Engineers Comments Regarding Surface Water Drainage

Application Reference:	WA/108/24/PL	Reviewer Reference:	ADC/SB
Planning Officer:	Amber Willard	Date of Review:	27/03/2025
Site Name:	Stoneybrook Farm Eastergate Lane Walberton BN18 0BA		
Application Description:	Erection of a re-purposed building for use as Class E (g) (iii) floor space, access, parking, drainage and landscaping. This application is in CIL Zone 3 (Zero Rated) as other development.		
Assessment Number:	1 of 1

Figure 4: Extract from Brookview Nursery Application

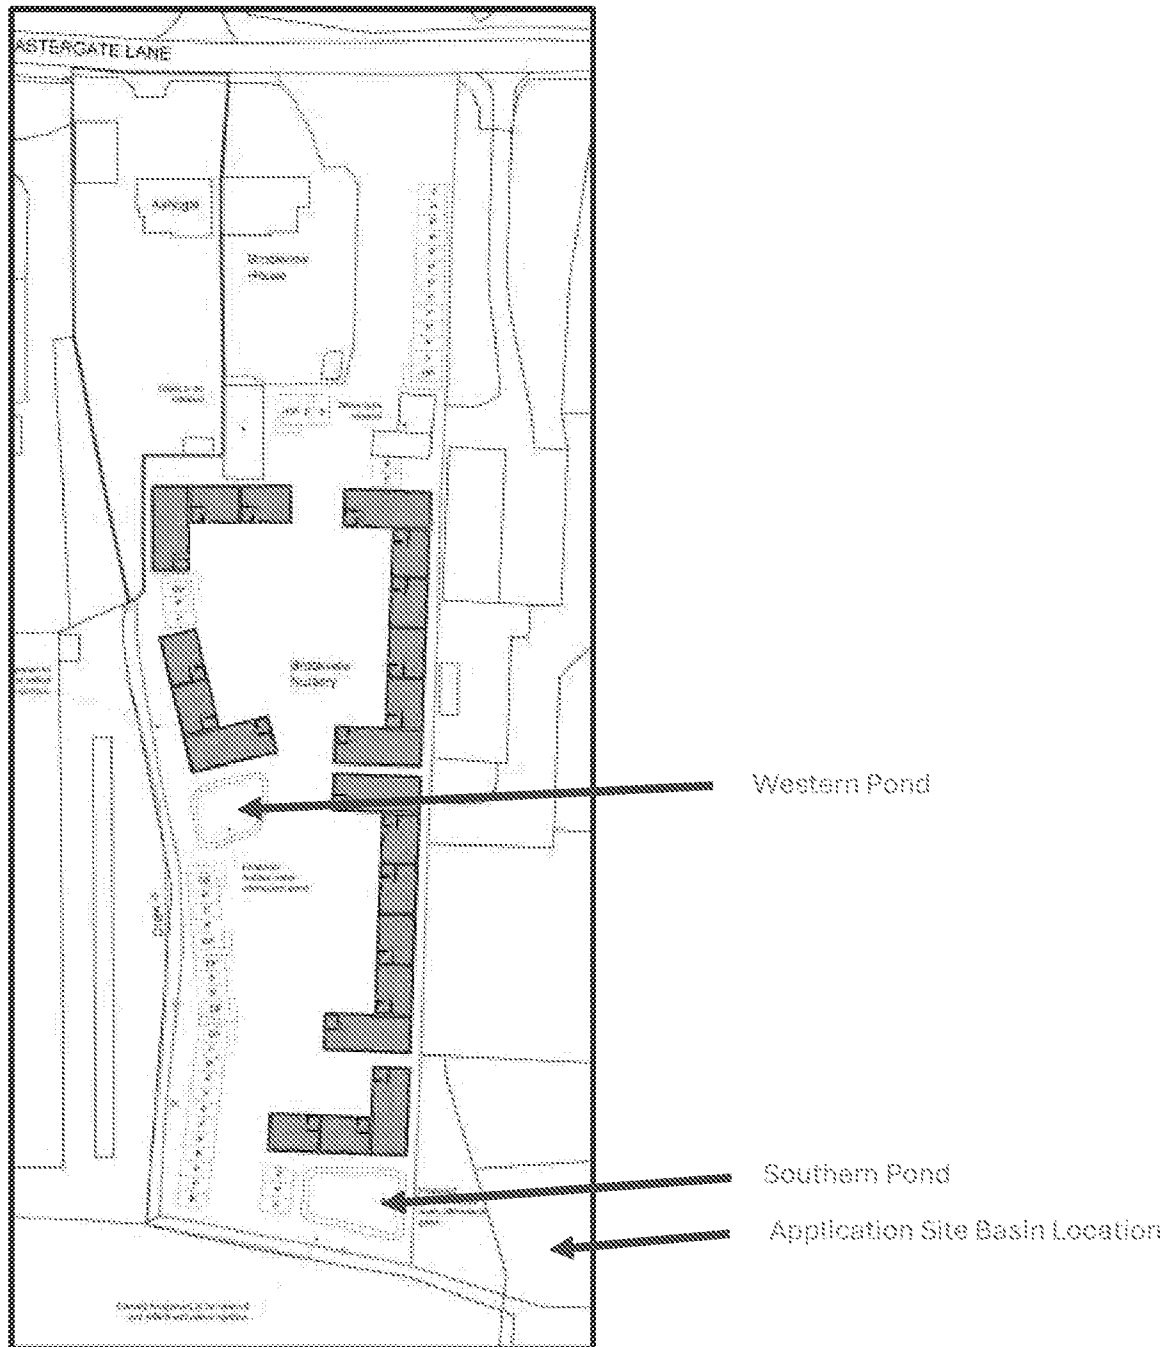
It is unclear if there may be infiltration potential on the site. This is because the designer has relied on site investigations from a neighbouring site. Infiltration tests must be completed in winter, at the proposed location, depth and head of water that any infiltration structure is proposed. The tests (and feature) must be at least 1m above the peak recorded groundwater level to provide adequate depth of unsaturated ground.

This means that the designer must have an accurate understanding of the groundwater levels. The proposed design relies on assumptions regarding the groundwater level based on the difference between the cover levels between this and the neighbouring site. This introduces an unacceptable level of uncertainty. It is likely that groundwater will be high enough that infiltration will not be a viable means of surface water disposal, even for a hybrid system (as proposed), due to the risk of groundwater entering the system during the lifetime of the development. However, this must be evidenced prior to approval.

Scheme as approved under ref.s
APPC3810/W23/3316638
WA8722/PL

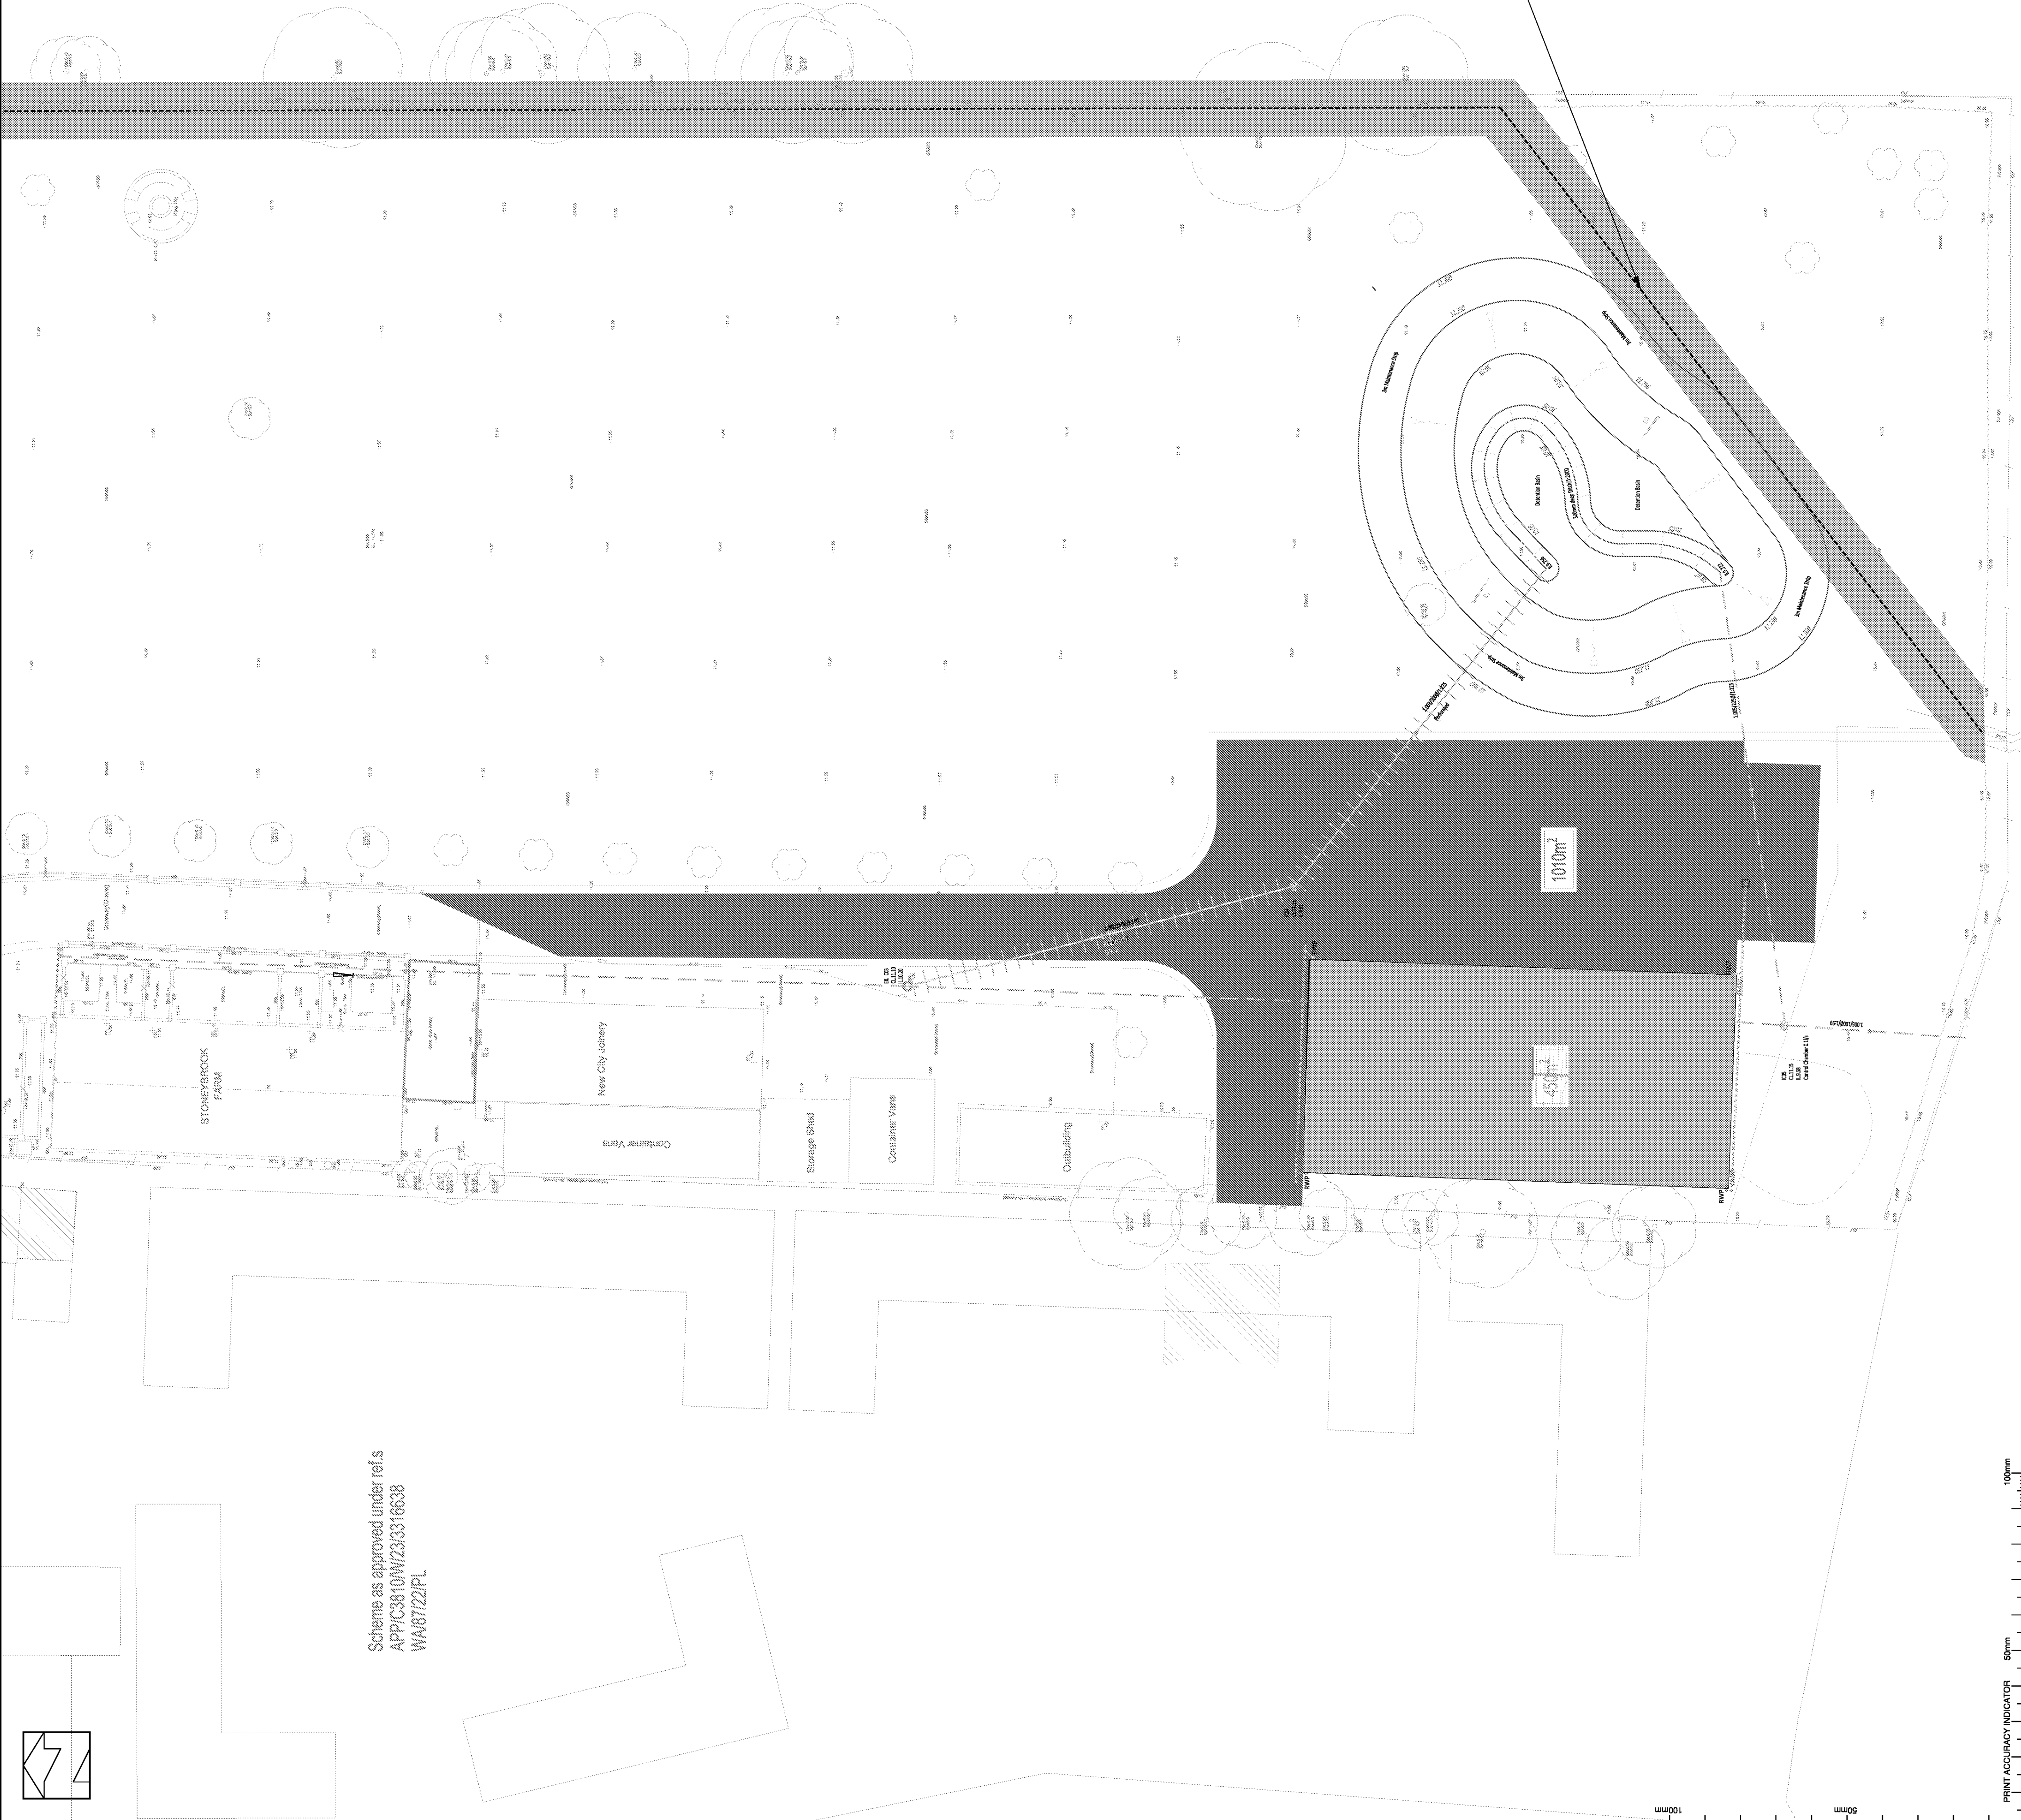
No information regarding the existing watercourse levels (true bed, top of bank and existing connection invert level) have been submitted. The proposed connection level according to the calculations appears to be significantly higher, however this appears to be due to land raising at the south of the site.

The modelling indicates that land south and east of the permeable paving will be raised to a level of 11.30m. The land south of the permeable paving currently falls towards the watercourse dropping to a level of 10.48m before the bank. The submitted documents imply that the land may be raised by up to 0.82m. This is not discussed within the FRA and the implications of this proposed land raising are not considered. Raising the ground levels to this extent may increase flood risk as it could disrupt the existing flow path towards the watercourse.

The designer must clarify the proposed levels to demonstrate that flood risk will not be increased by the proposed development. They must illustrate the extent of any ground raising and that a gravity design can be achieved with a connection to the watercourse.

1. Provide evidence that a gravity connection to the boundary watercourse can be achieved, this must include detailed levels information with the outlet to the watercourse a minimum of 150mm above the ditch bed.
2. Demonstrate that flood risk will not be increased by proposed ground raising on the site.
3. Clearly show the location and easement for the watercourse on plans.
